TRAILS AT ASPEN RIDGE FILING NO.1

ROADWAY & STORM IMPROVEMENT PLANS

JULY, 2019

TRAILS AT ASPEN RIDGE			
FILING NO. 1 ROADWAY & STORM IMPROVEMENT PLANS			
LEGACY DRIVE PLAN & PROFILE			
DESIGNED BY: NMS	SCALE: HORIZ 1" = 40'	DATE ISSUED: JULY, 2019	DRAWING No. TY01
CHECKED BY: NMS	VERT. 1" = 8'	SHEET 3 OF 71

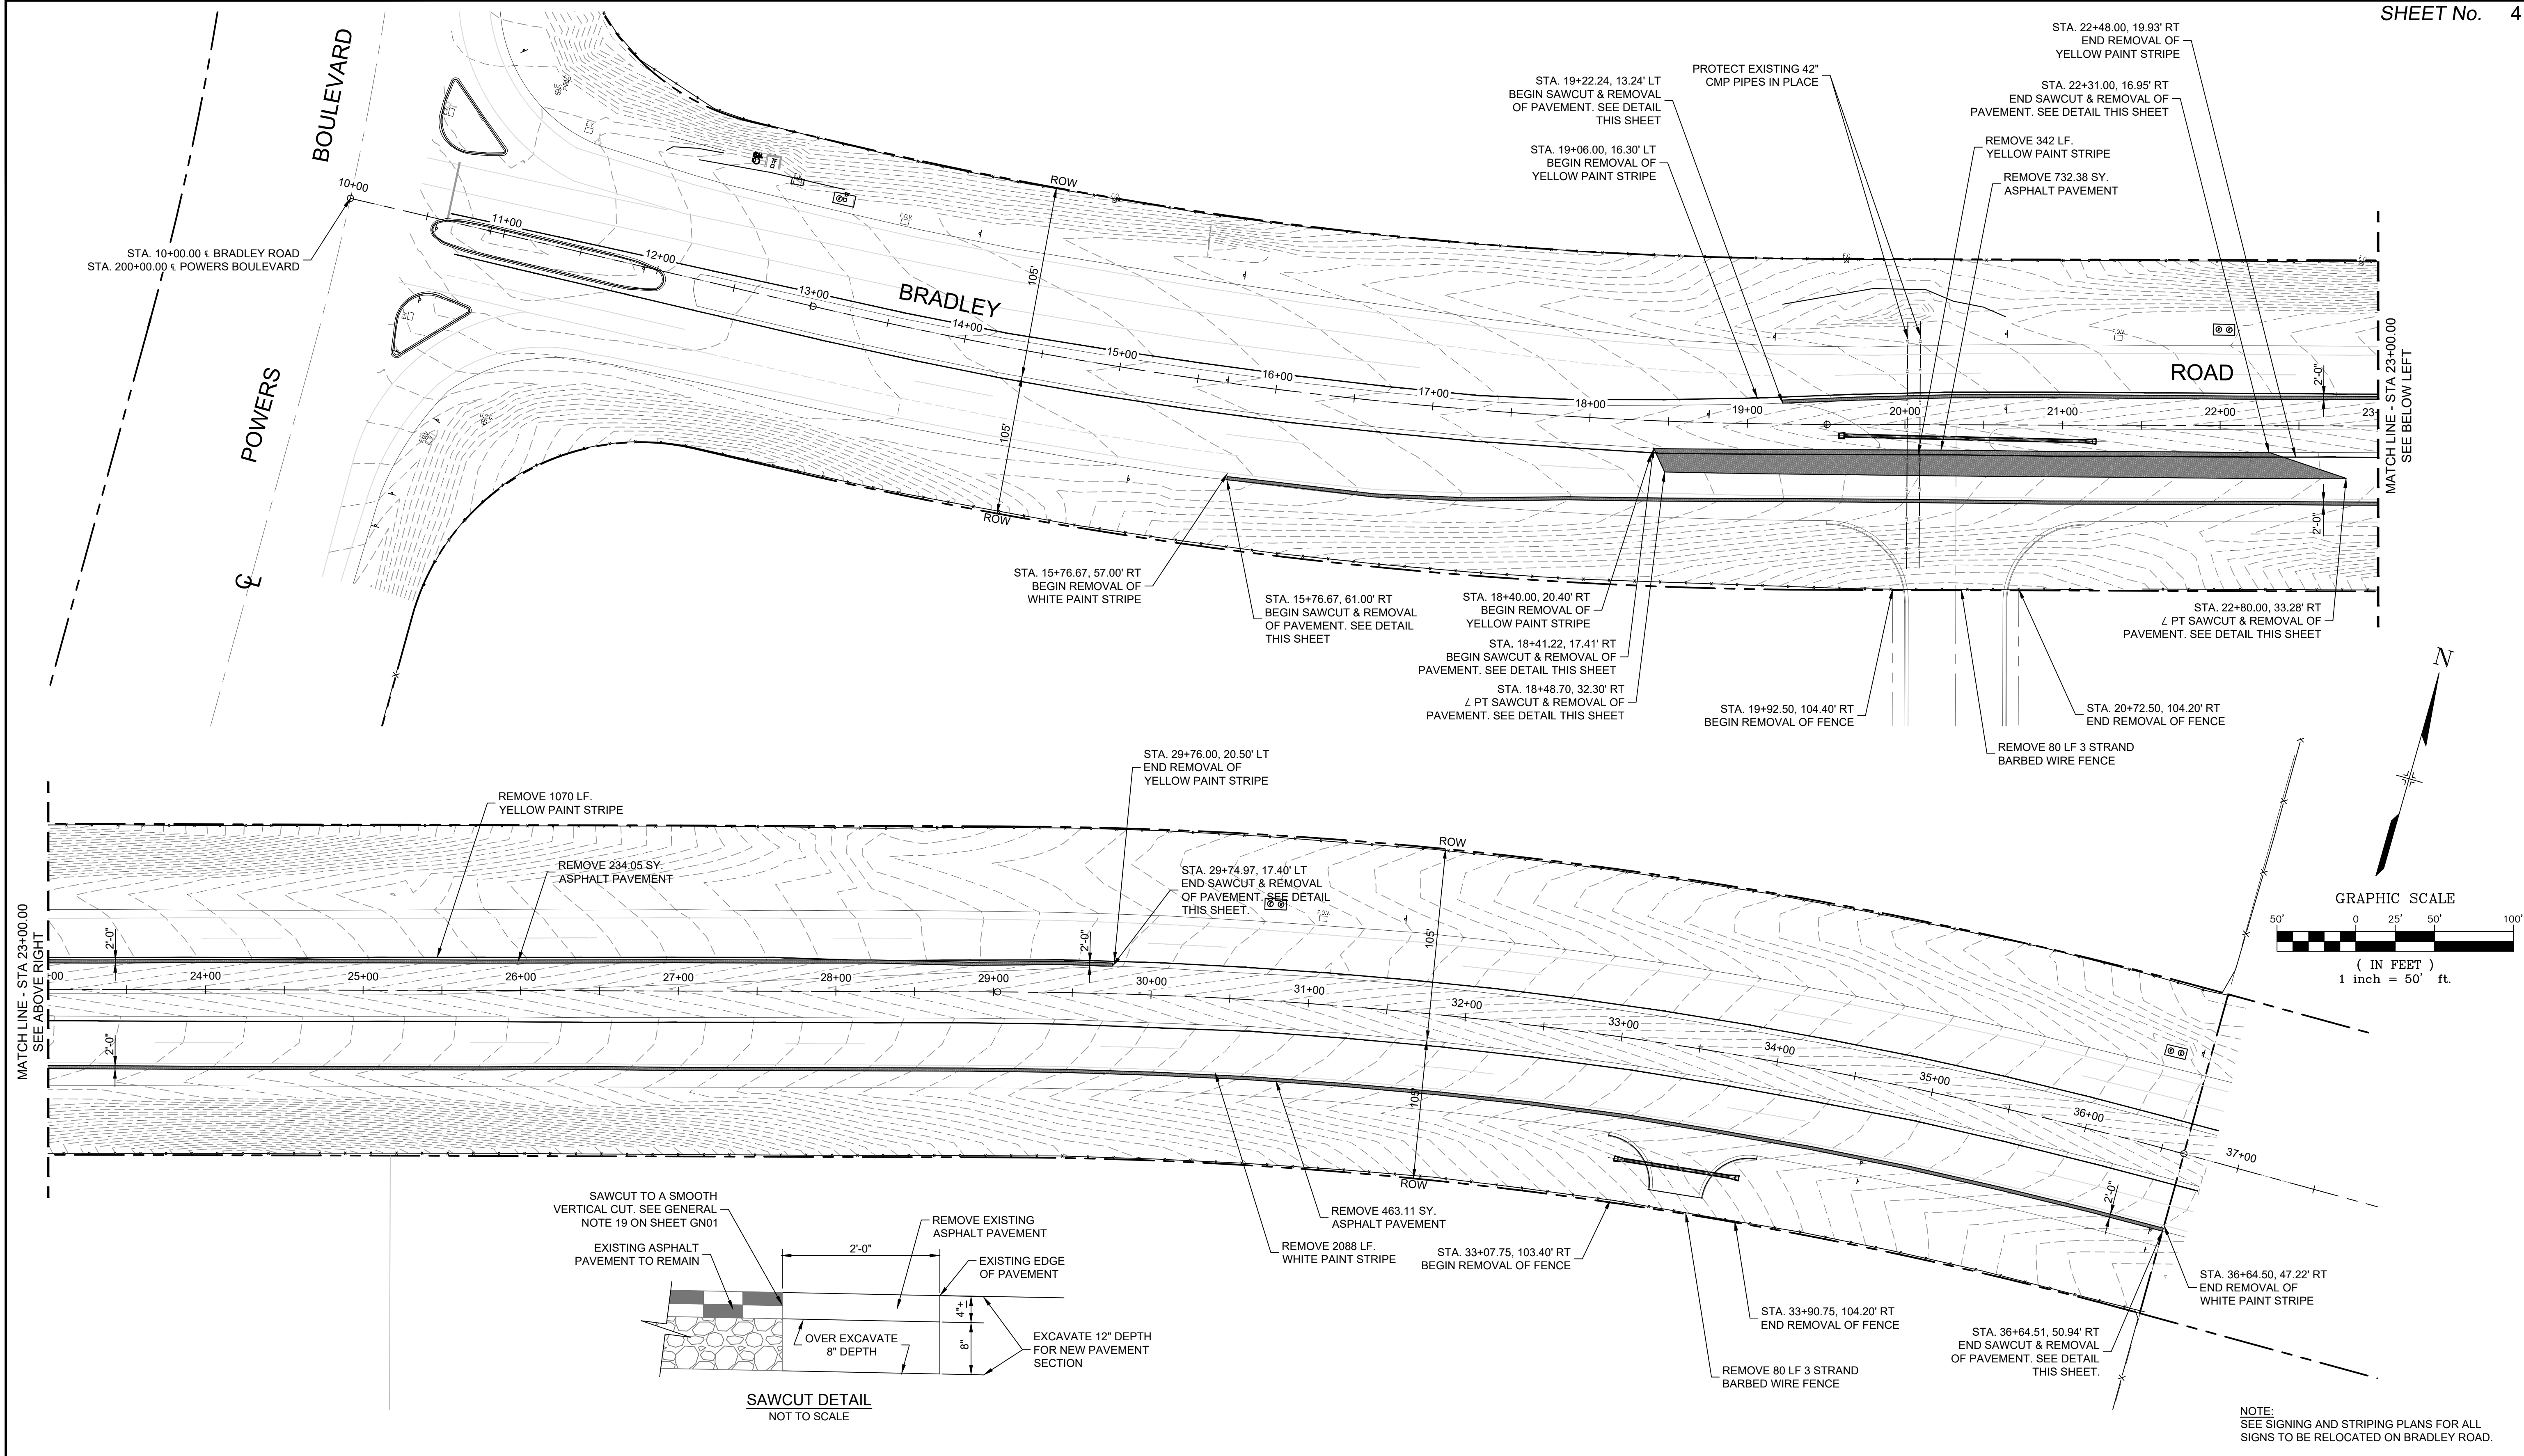
Provide a typical cross section for the local road.
Ramp cubs used with the local road shall be the EPC Optional Type C

Revise to 8' paved shoulder per ECM
criteria for rural minor arterial.

Provide the 6' shoulder. ROW will need to be wider to accommodate the roadway cross-section

Replace "Varies" with the min - max range.
Typical for all cross sections.

adjust C & G leader

Add note that what's shown is the minimum pavement section. The required pavement section will be per the pavement design report.

Provide shoulder to continue through to the above typical section. See striping plan

Recommend showing the Tract where sidewalk meanders into.

Provide typical section for front side drive. Per the TIS front side is to be urban non-residential collector
